# **East Anglia ONE North and East Anglia TWO Offshore Windfarms**

## **Applicants' Comments on Marine Management Organisation's Deadline 3 Submissions**

Document Reference: ExA.AS-17.D4.V1

Date: 13<sup>th</sup> January 2021

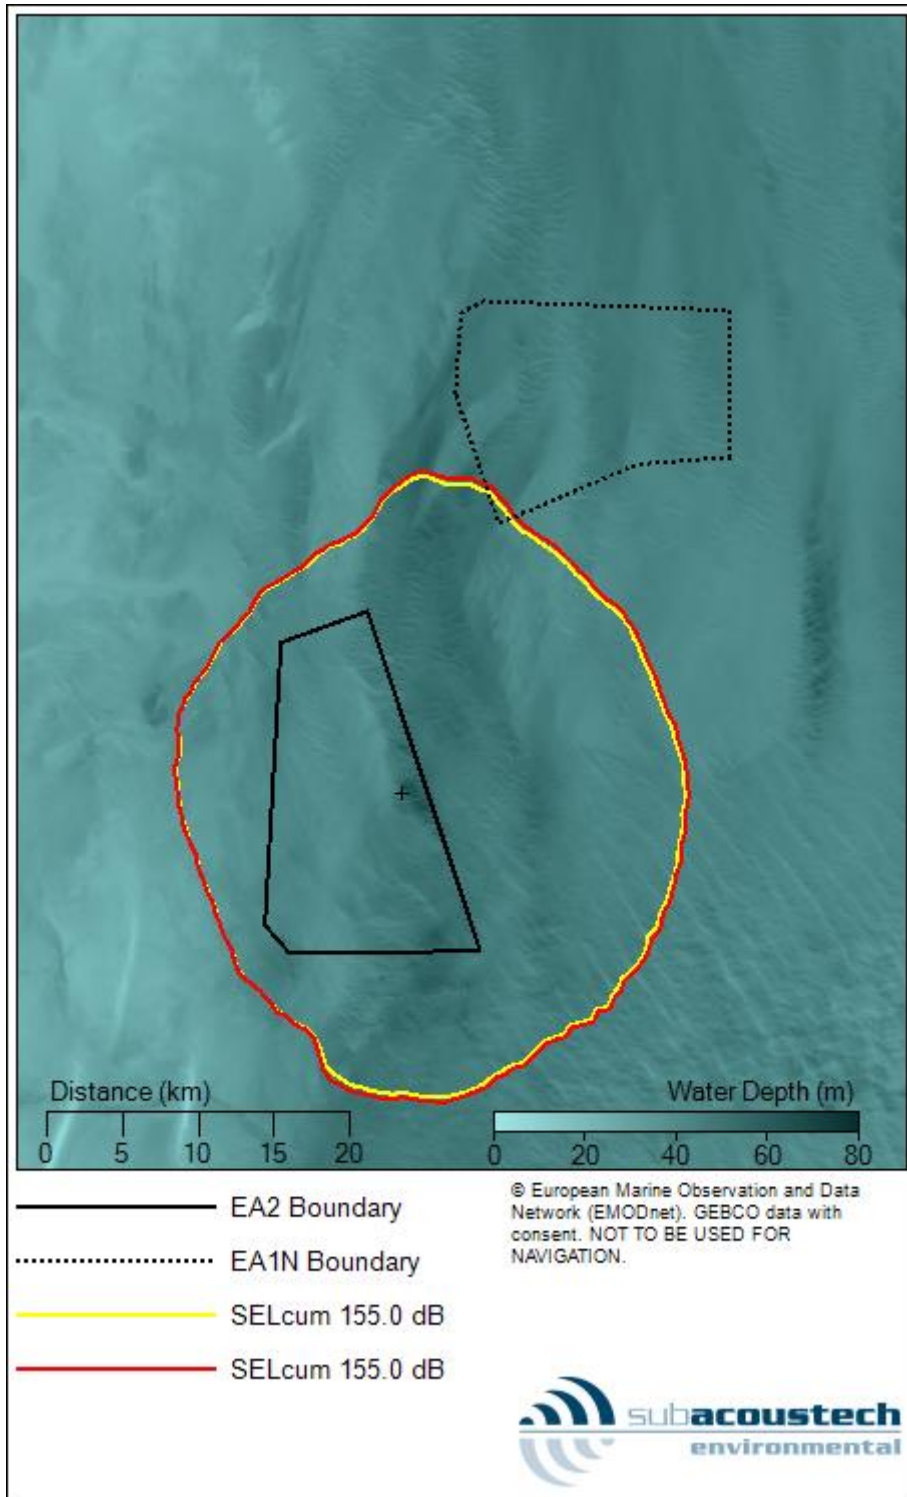
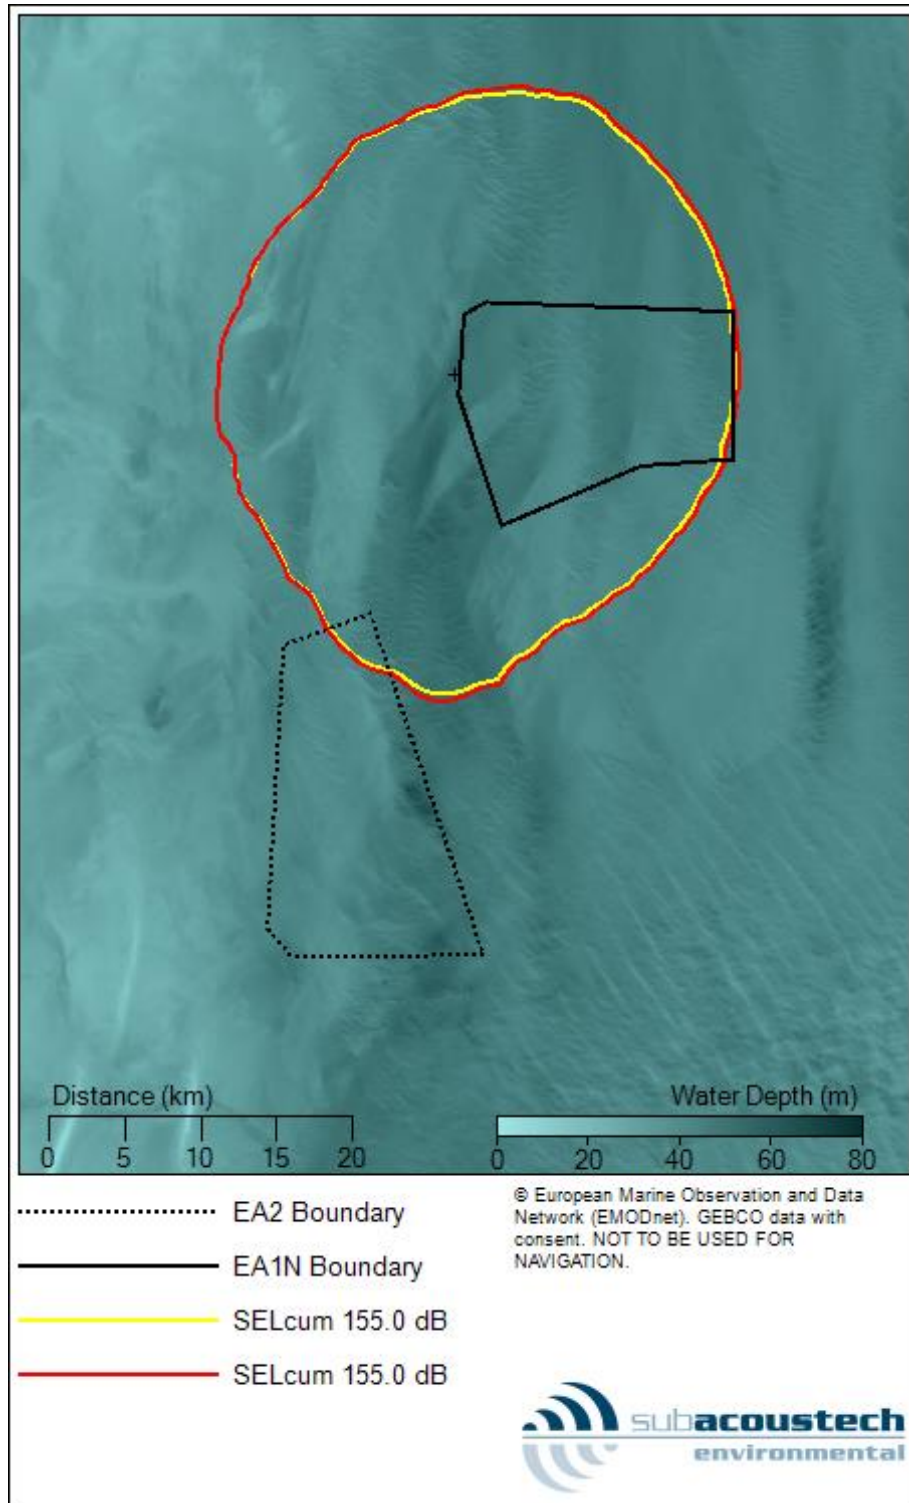
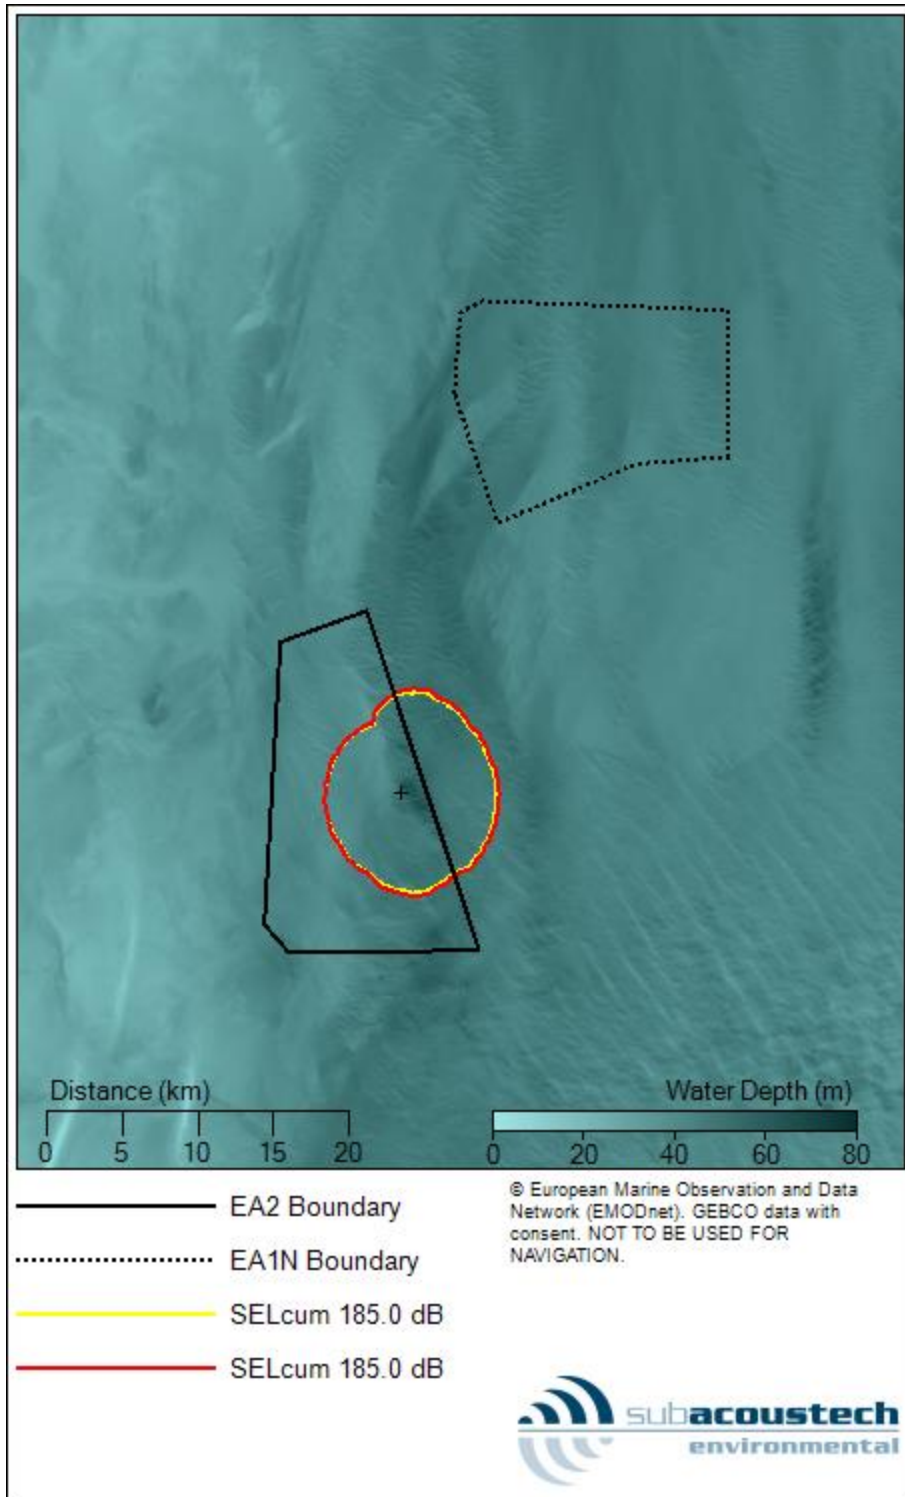
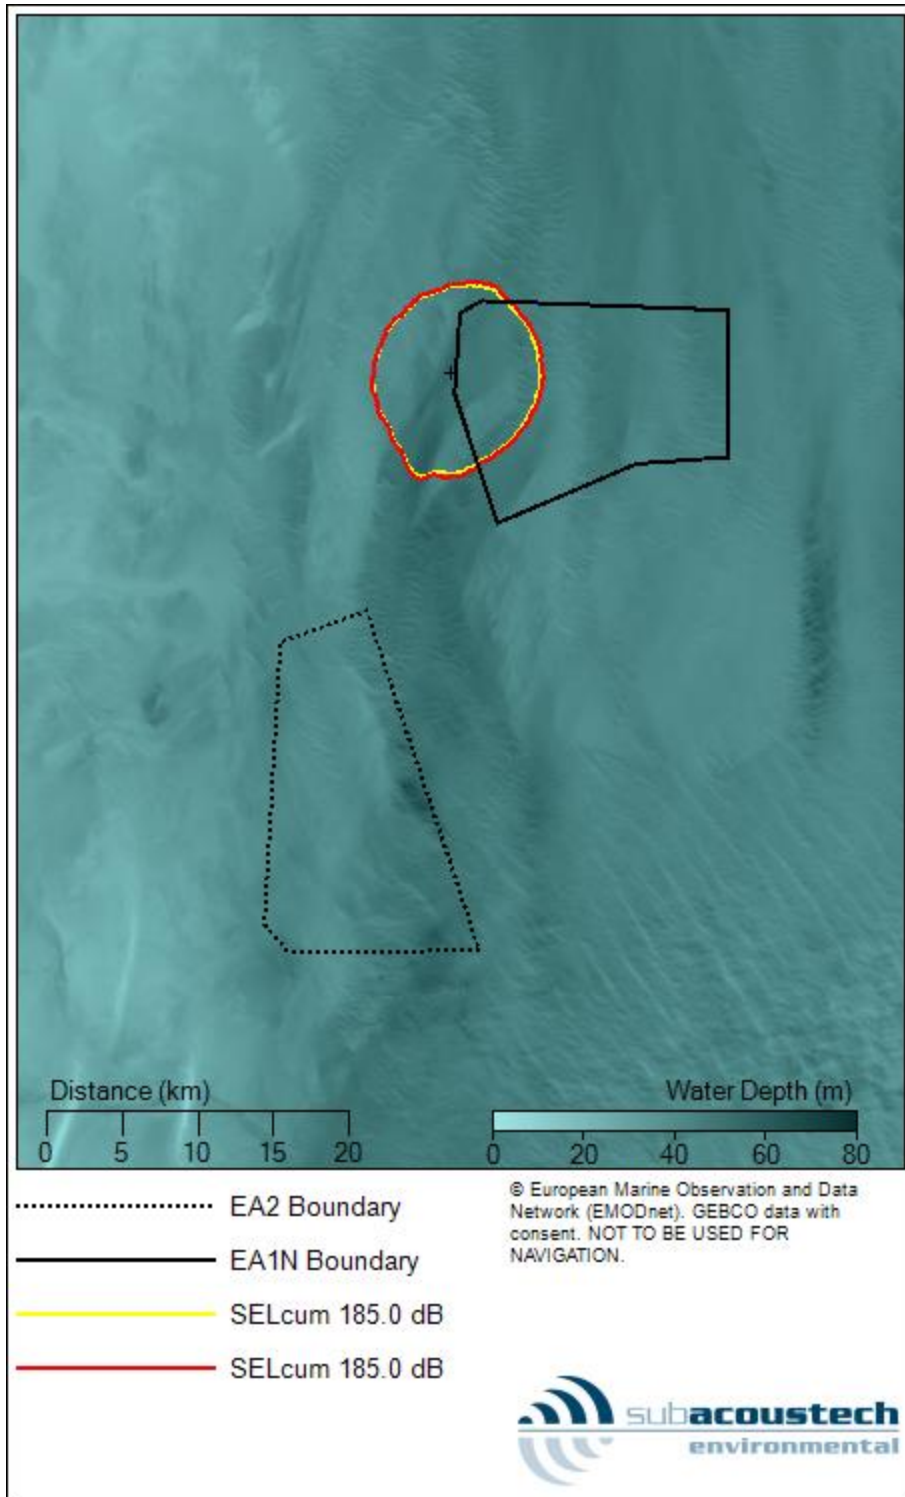
Point	MMO Comment	Applicants' Response
2.5h	The MMO notes that the Applicant has considered maximum impact range for Permanent Threshold Shift (PTS) of up to 11.1km using peak sound pressure level (SPL <sub>peak</sub> ) criteria as a mitigation measure to be included in their MMMP. The MMO reserves comment on this until the updated document is reviewed and will provide comments at Deadline 4.	Noted
